**Nationally Significant Infrastructure Project: EN01027  
Mallard Pass Solar Farm**

**Response to The Examining Authority's written questions and requests for  
information (ExQ1) issued on 23 May 2023**

**Prepared by Lincolnshire County Council**

**June 2023**

Z:\7863_NSIP_SOLAR_FARM_CONFIDENTIAL\GIS\PROJECTS\1\7863_106_LVIA_ZTV_A3.MXD

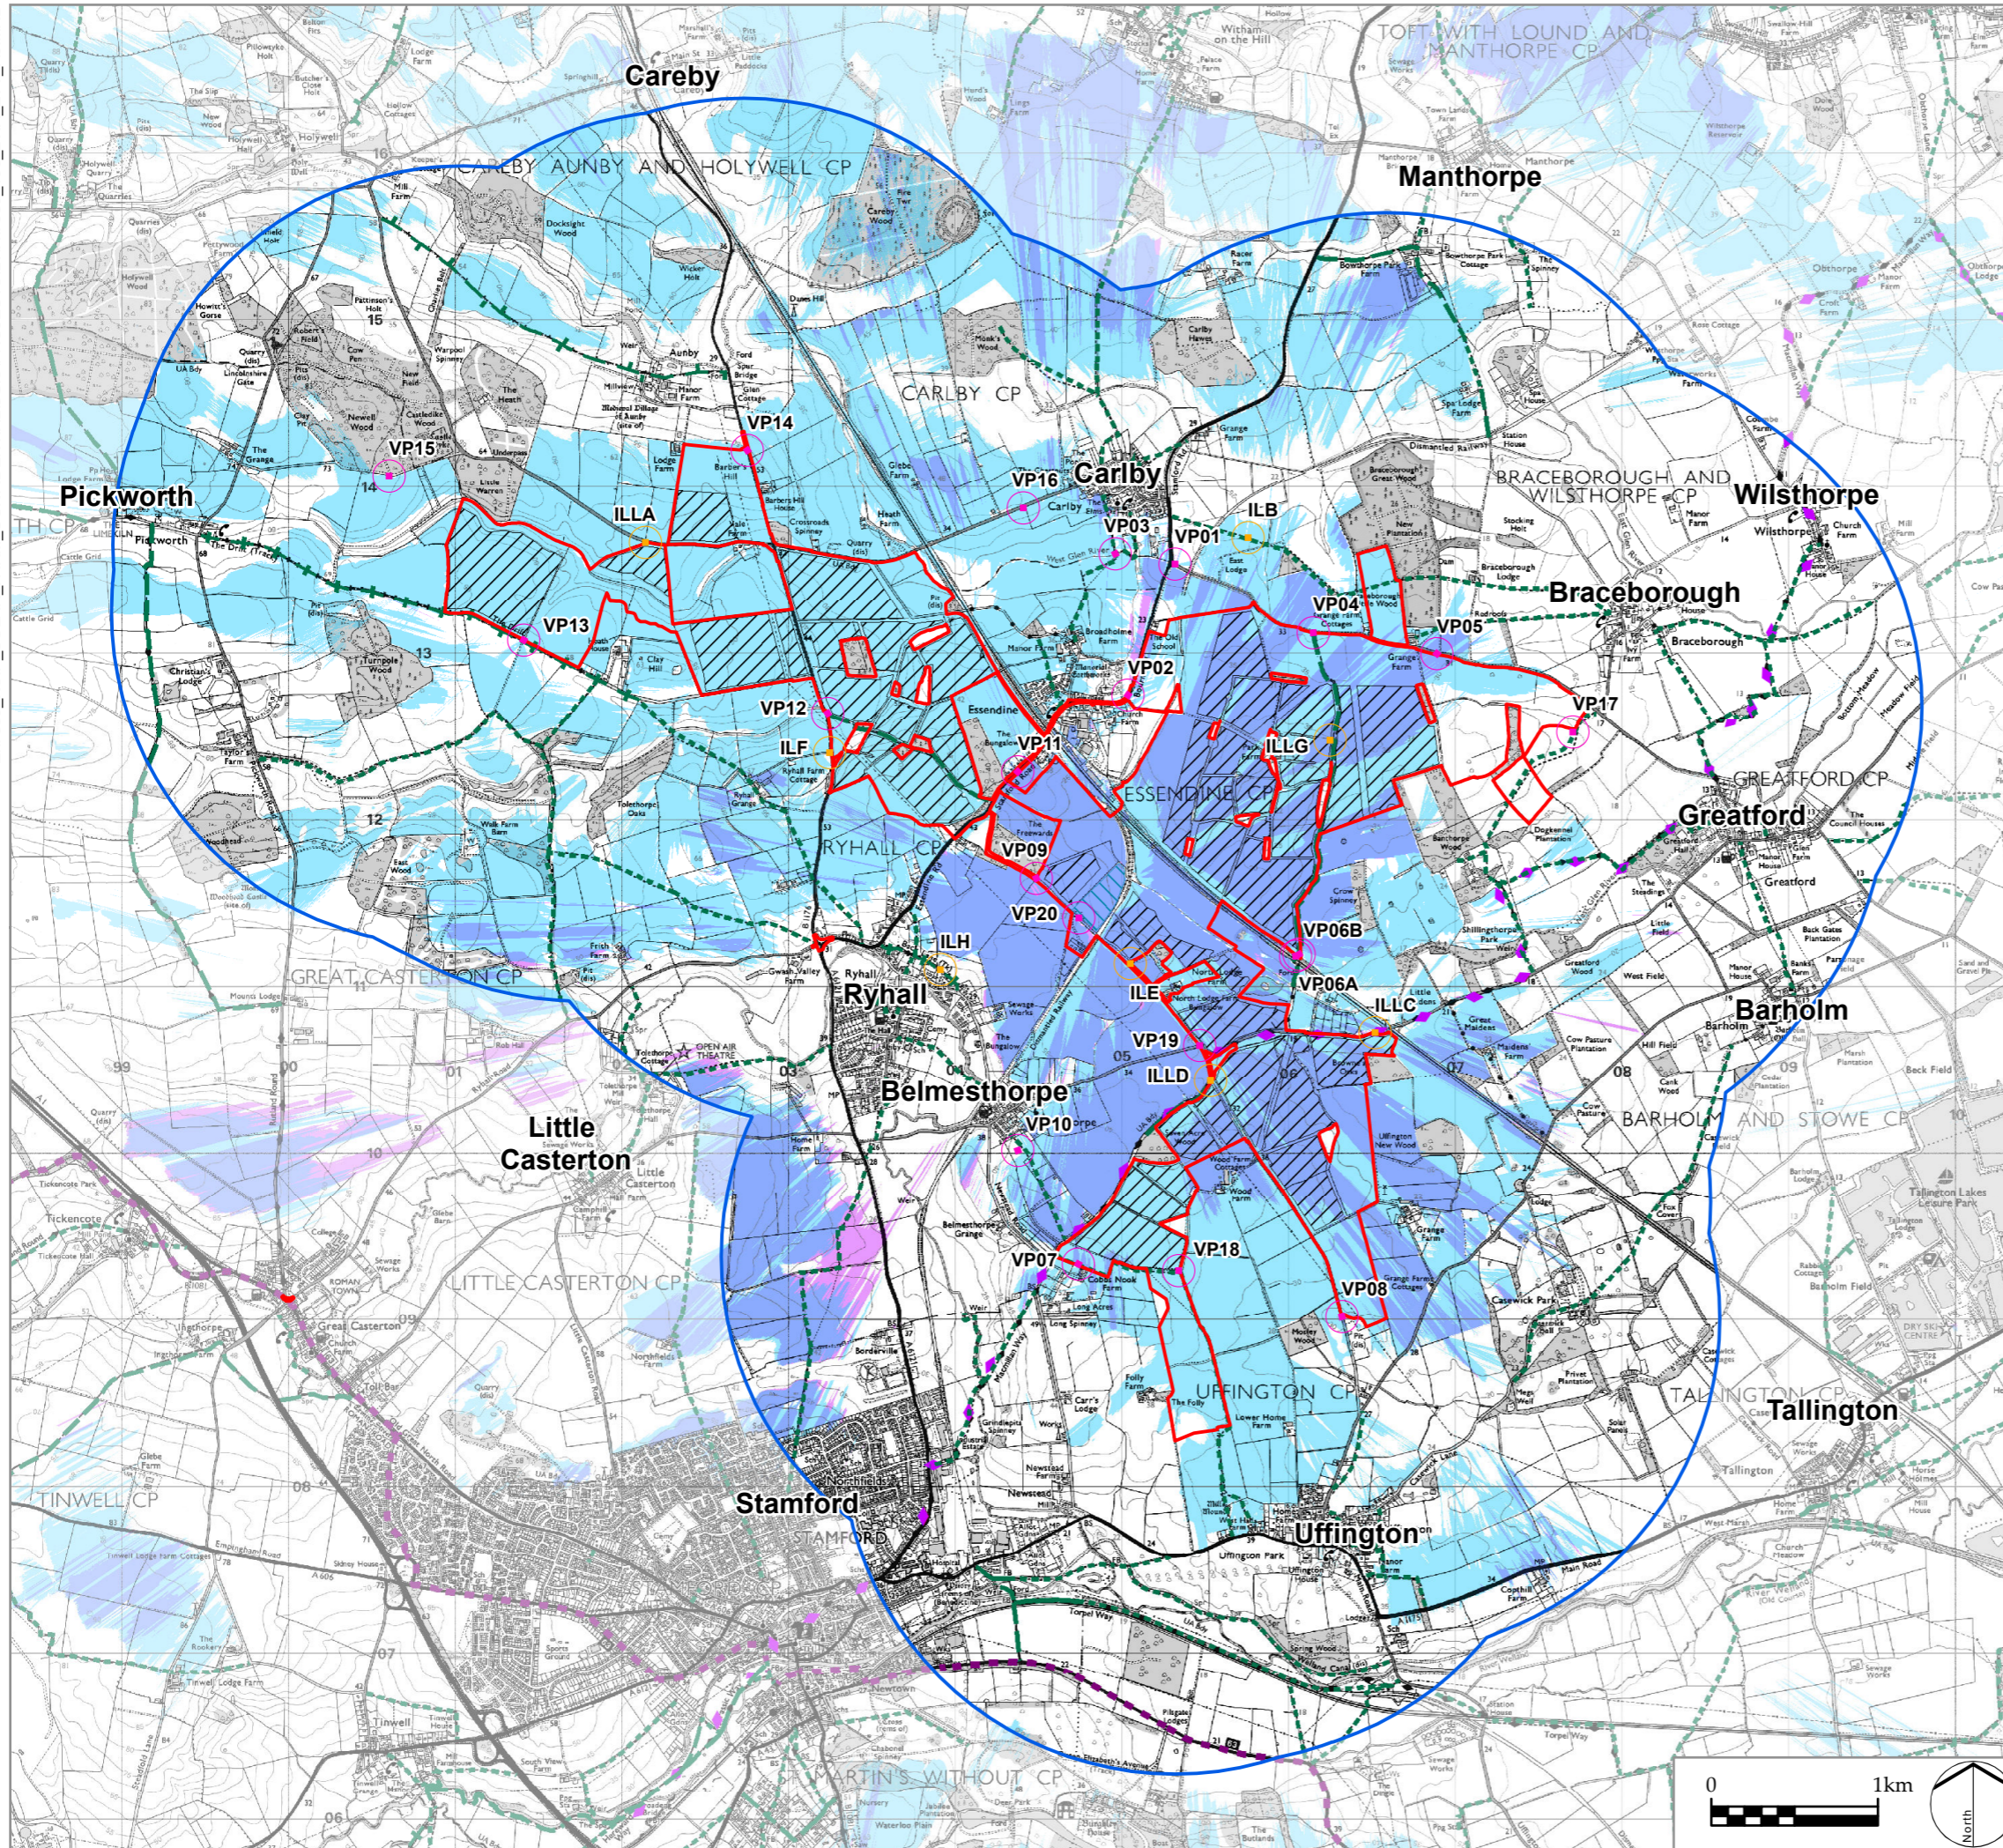
| ExQ1     | Question   | LCC Response   |
|----------|--|--|
| Q8.0.5   | <p>Figures 6.6 <a href="#">[APP-138]</a> and 6.7 <a href="#">[APP-139]</a> of the ES show the representative viewpoints, illustrative viewpoints and visual receptor groups, further details of which are provided in paragraphs 6.3.50 to 6.3.58 of the ES <a href="#">[APP-036]</a>.</p> <p>Please confirm if you agree with these viewpoints and visual receptor groups. If you consider that any further viewpoints would be reasonably required, provide precise details of these along with a clear justification for why they are required.</p> | <p>Whilst the selection of the viewpoints has been discussed with LCC during the pre-application consultation stage, the exact locations have not in all instances been agreed. See Local Impact Report for more details.</p>  |
